**TOWN AND COUNTRY PLANNING ACT 1990 (AS AMENDED)
SECTION 96A (NON-MATERIAL AMENDMENT) APPLICATION TO PLANNING PERMISSION
REF: 2026/90937 (REDEVELOPMENT OF SCHOOL) FOR PROPOSED MINOR AMENDMENTS
TO APPROVED LAYOUT
GOMERSAL ST MARY'S PRIMARY SCHOOL, SHIRLEY AVE, GOMERSAL, BD19 4NA**

On behalf of Bowmer and Kirkland Limited (B+K) for Gomersal St Mary's Primary School and the Department for Education (The DfE), enclosed is an application proposing minor changes to the layout associated with planning permission ref: 2026/90937.

Figure 2: UK Habs Map Showing Post-Development Habitats

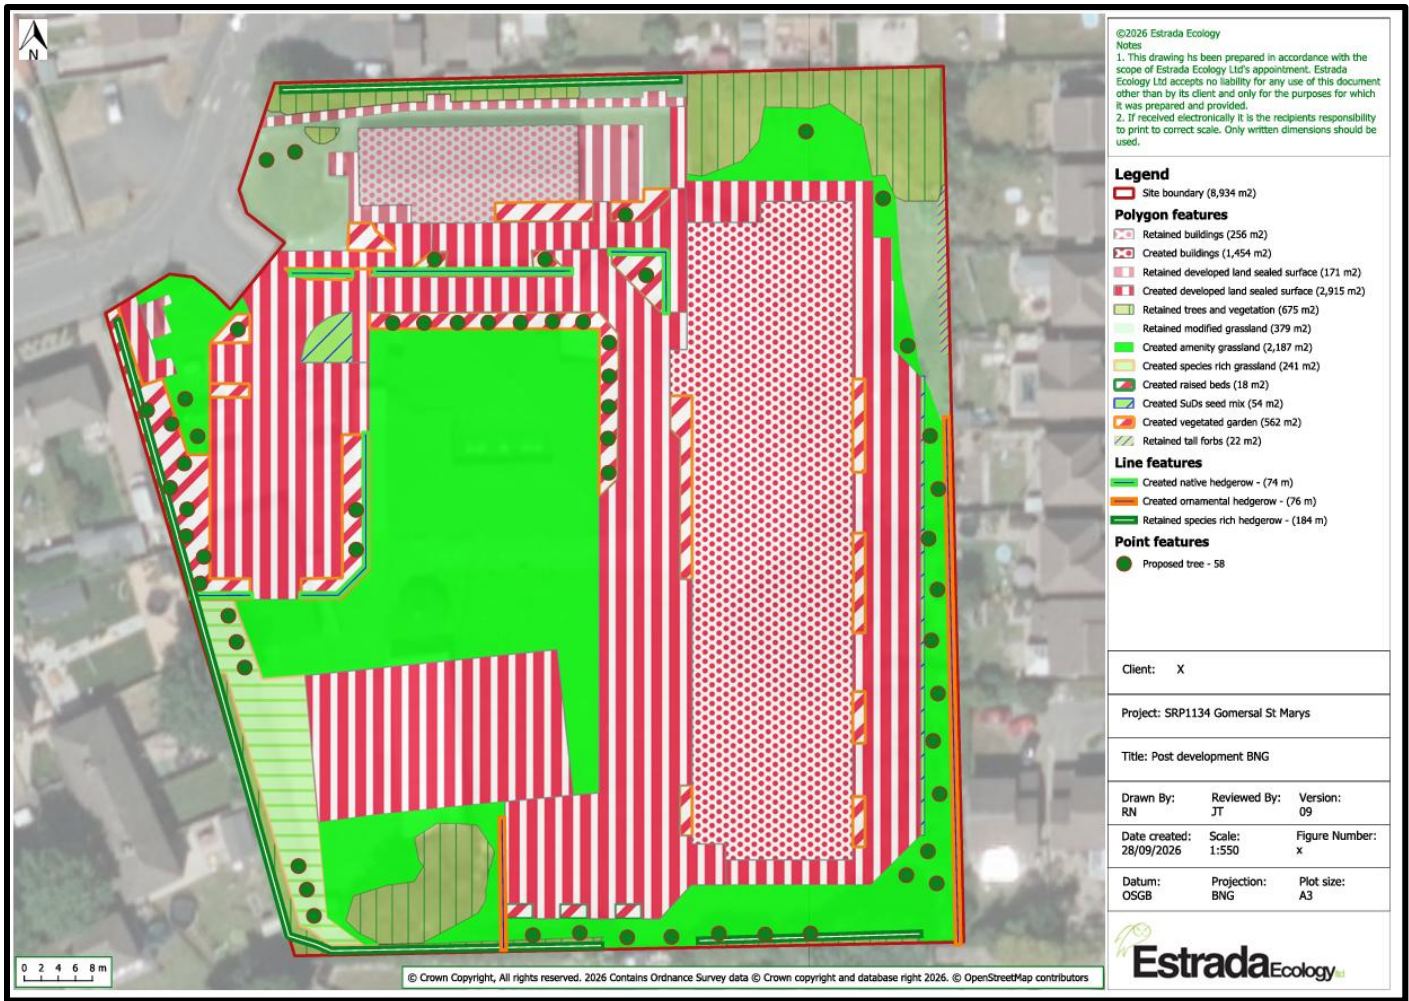
Alterations to landscaping to the northeast

The approved scheme included an instant hedge screen along the north-east boundary to address privacy concerns from neighbouring properties. The proposed amendment seeks to retain and manage the existing vegetation where it is already present, rather than replacing it with new hedging. The existing vegetation is taller and denser than the approved instant hedge screen and therefore provides an equivalent, if not improved, level of screening. Neighbours on the opposite side of the boundary have also requested that the vegetation is cut back and managed where necessary and the applicant is happy to accommodate this request. Instant hedging will still be provided in locations where no existing vegetation exists, and the total number of trees proposed across the site remains unchanged. The submitted landscaping plans reflect the above minor amendments and the impact on biodiversity net gain as a result of the landscape changes is negligible. As opportunities for habitat creation within the site have been fully maximised, 2.71 off-site biodiversity units are required to offset the residual loss and secure the mandatory 10% Biodiversity Net Gain which reflects the same number of units approved as part of the approved Biodiversity Gain Plan Condition. The Biodiversity Gain Plan Condition will be re-discharged to reflect this minor change.

DWG No. SRP1134-ONE-ZZ-XX-D-L-0014 REV P04

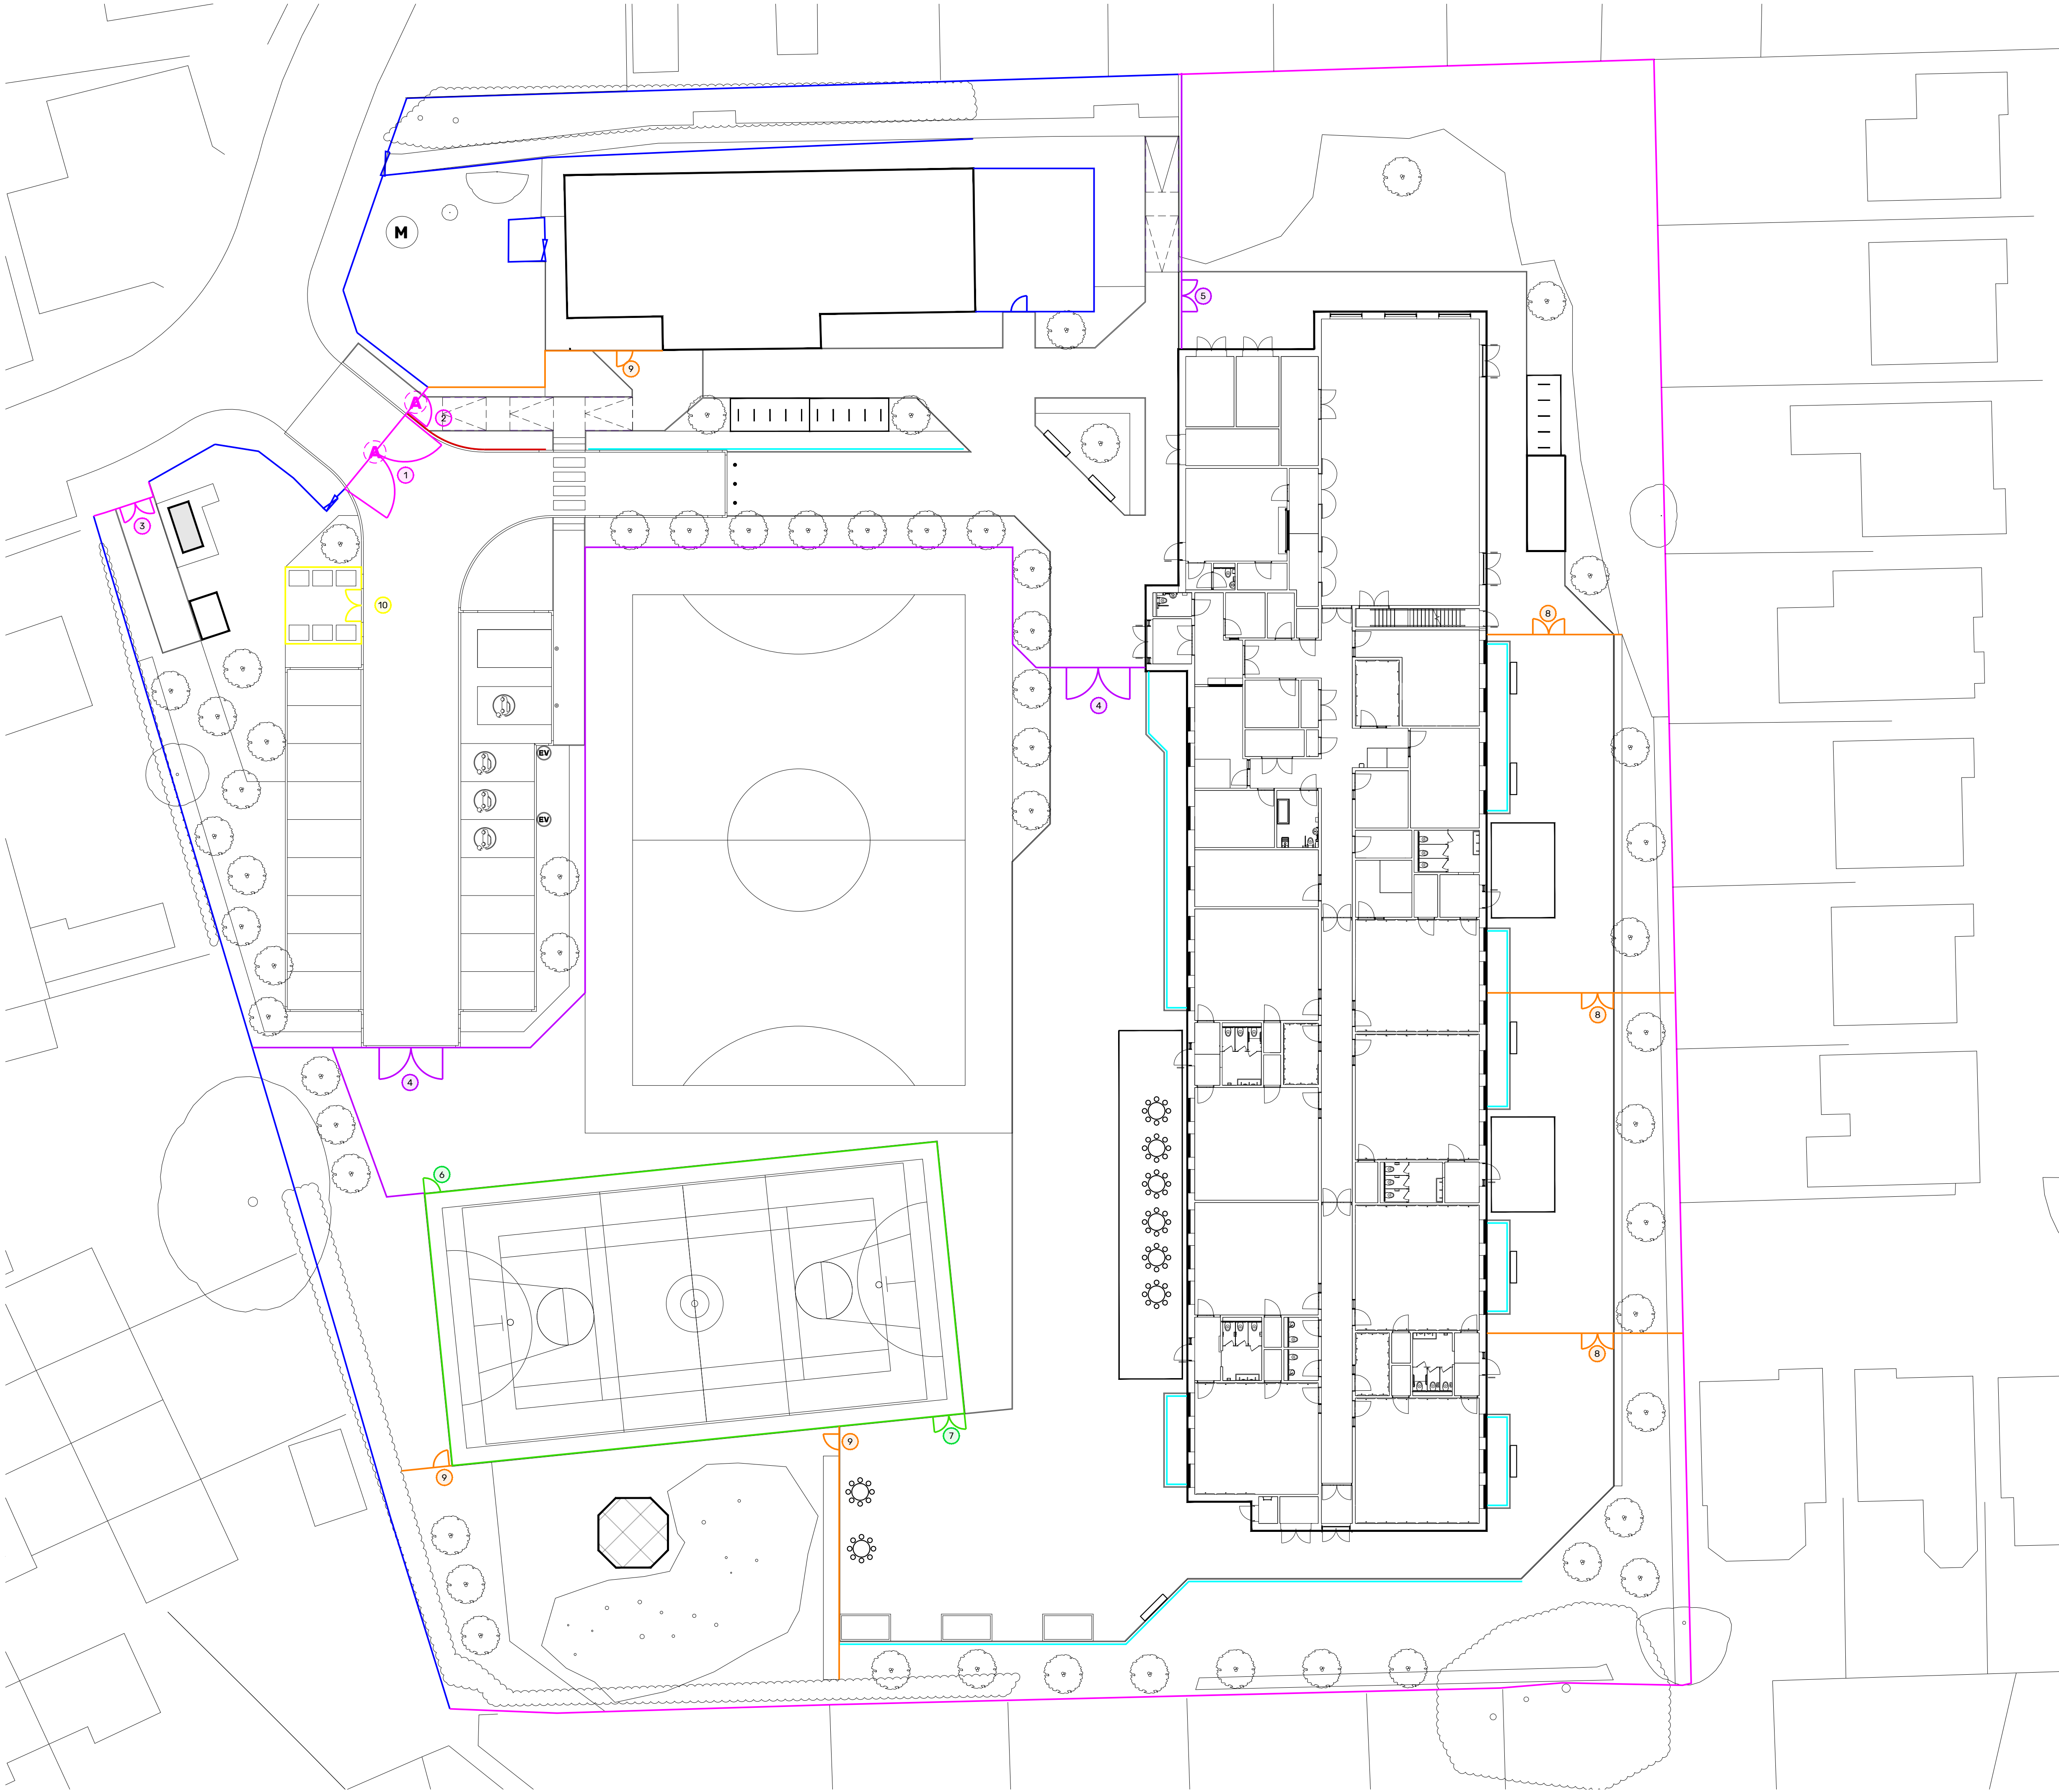
Omission of one gate and associated access into Hard PE area

One gate and the associated access point into the hard PE area are proposed to be removed due to the required soil cover above the attenuation tank. This amendment is necessary to accommodate the drainage infrastructure while ensuring appropriate cover levels are maintained above the tank.

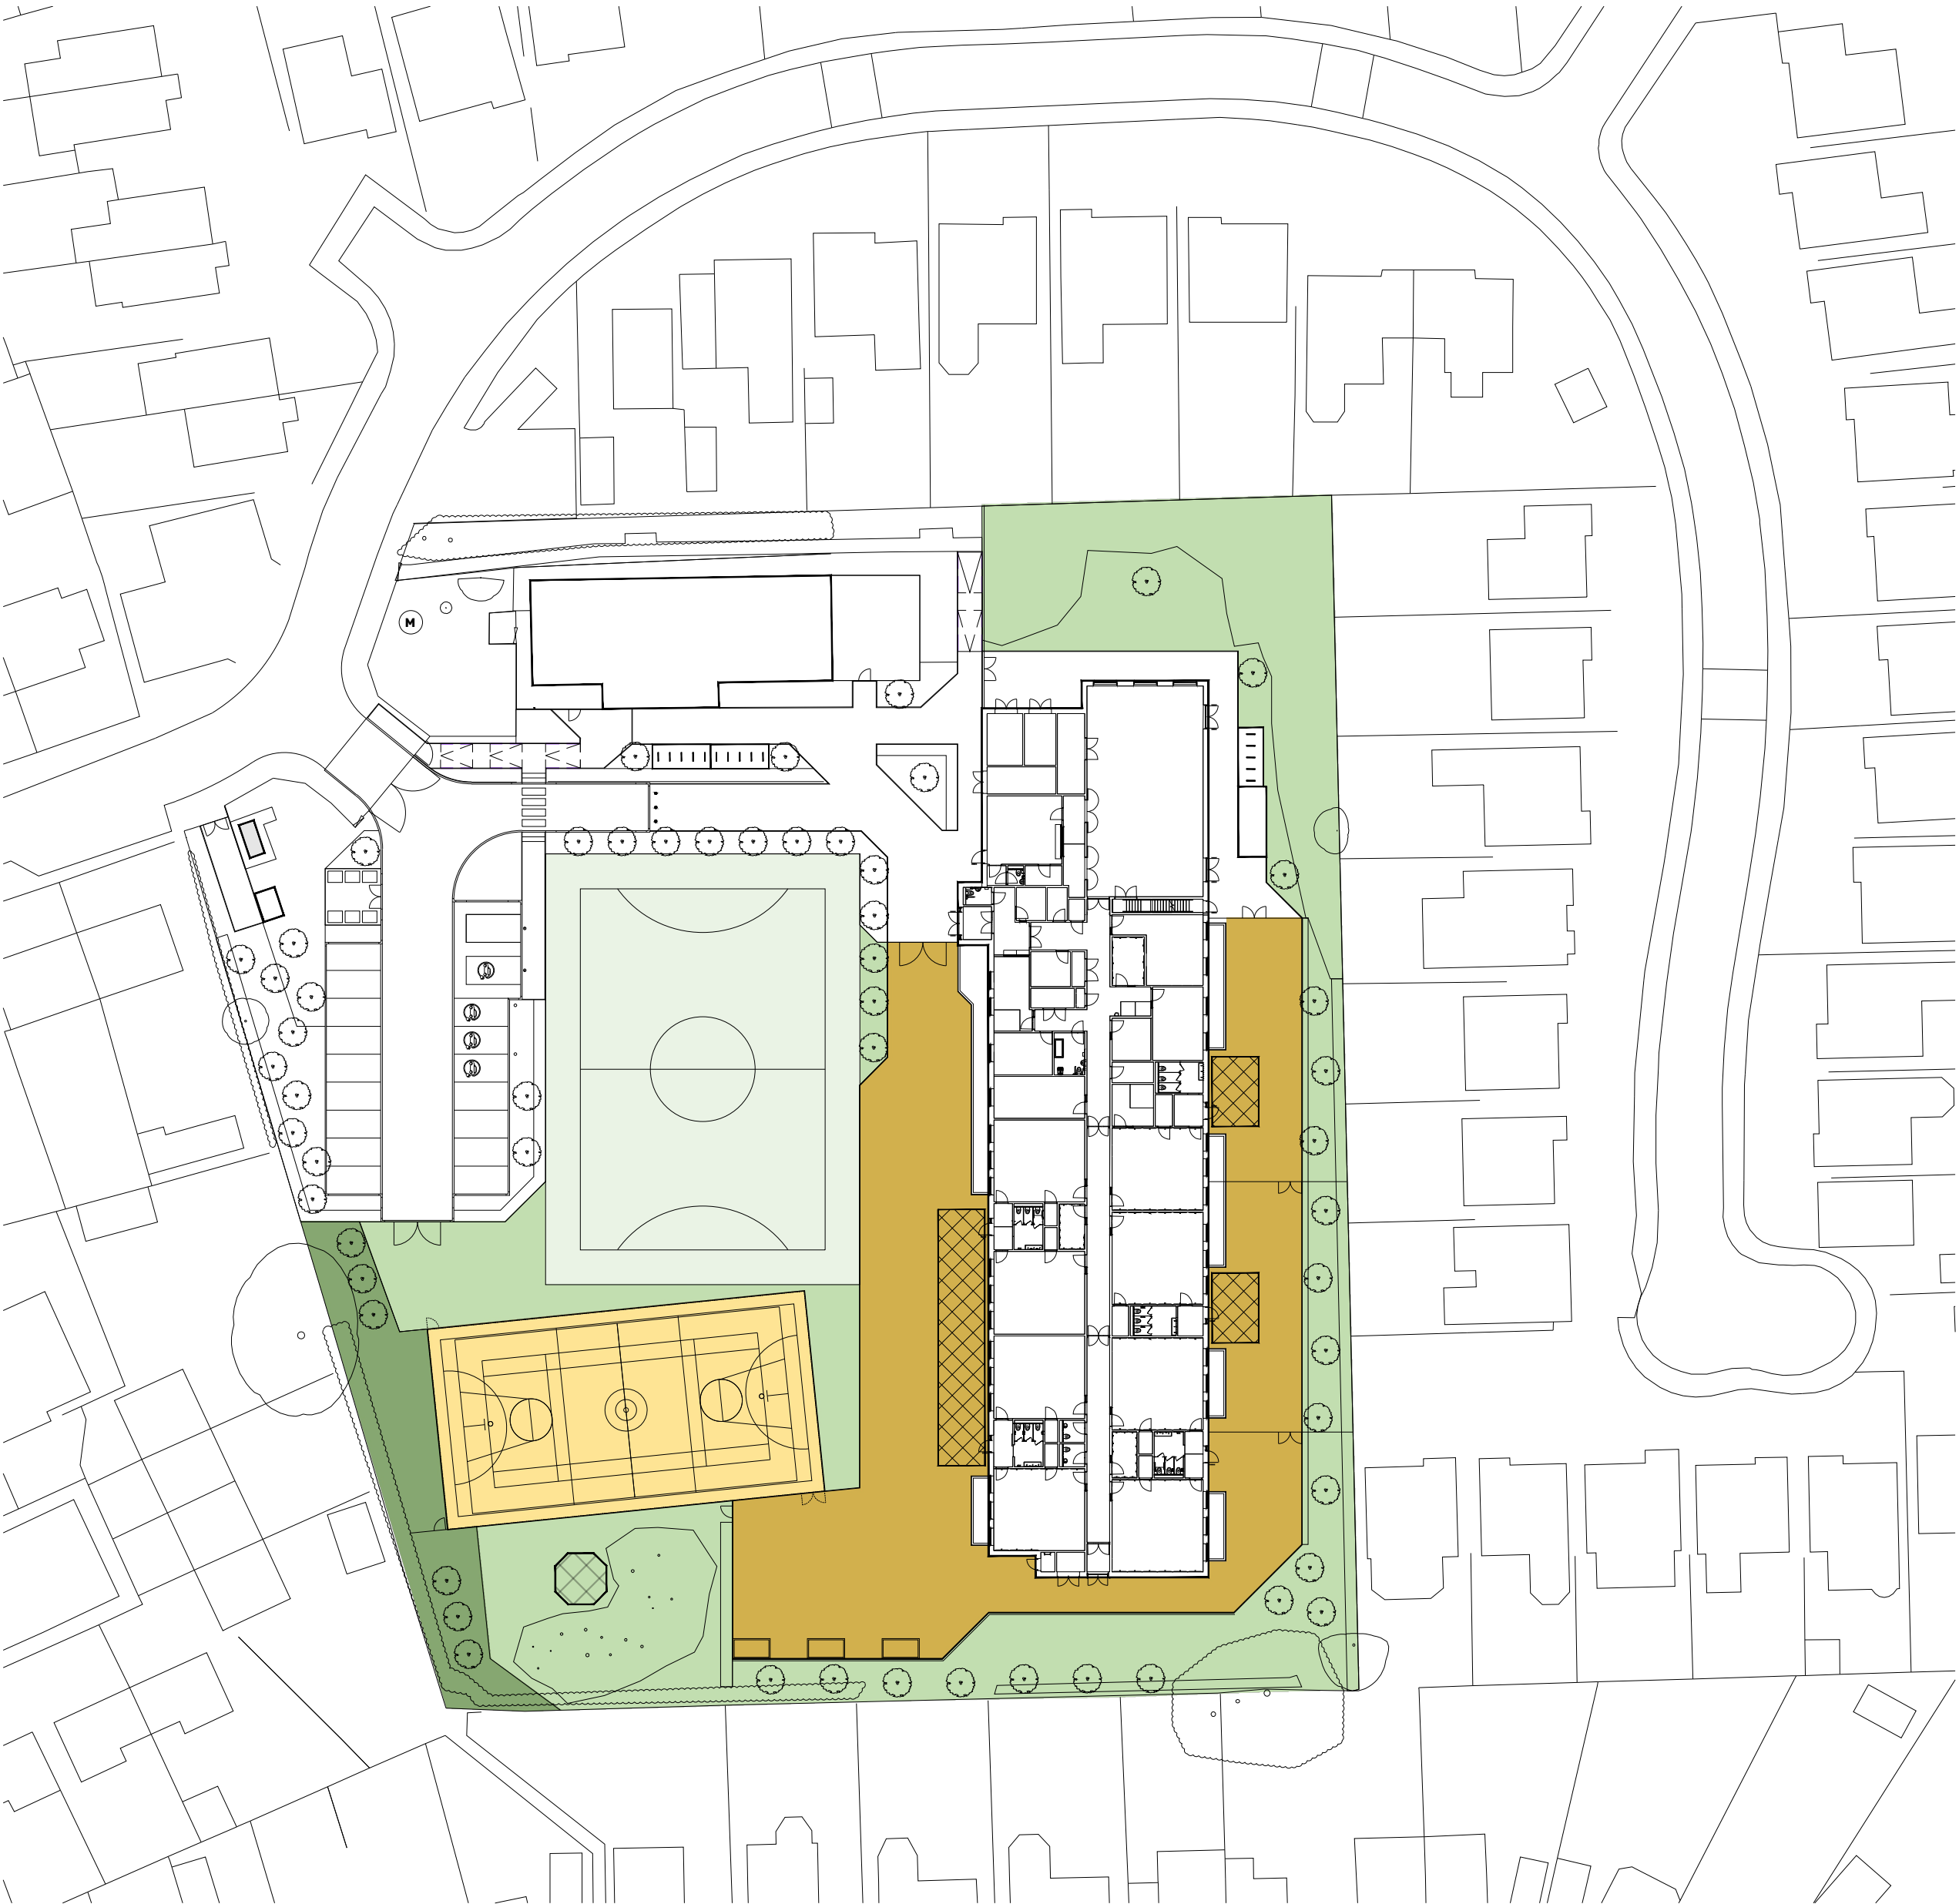
Change to Hard PE Area positioning

The hard PE area is proposed to be moved approximately 1.5m to the west to allow the drainage inspection chambers to be located outside of the playing area. This will ensure the drainage system can be accessed and maintained without affecting use of the hard PE area. Extracts from the approved and revised whole site plans have been provided below for comparison (the repositioned hard PE area remains within the location of the existing hard PE area).
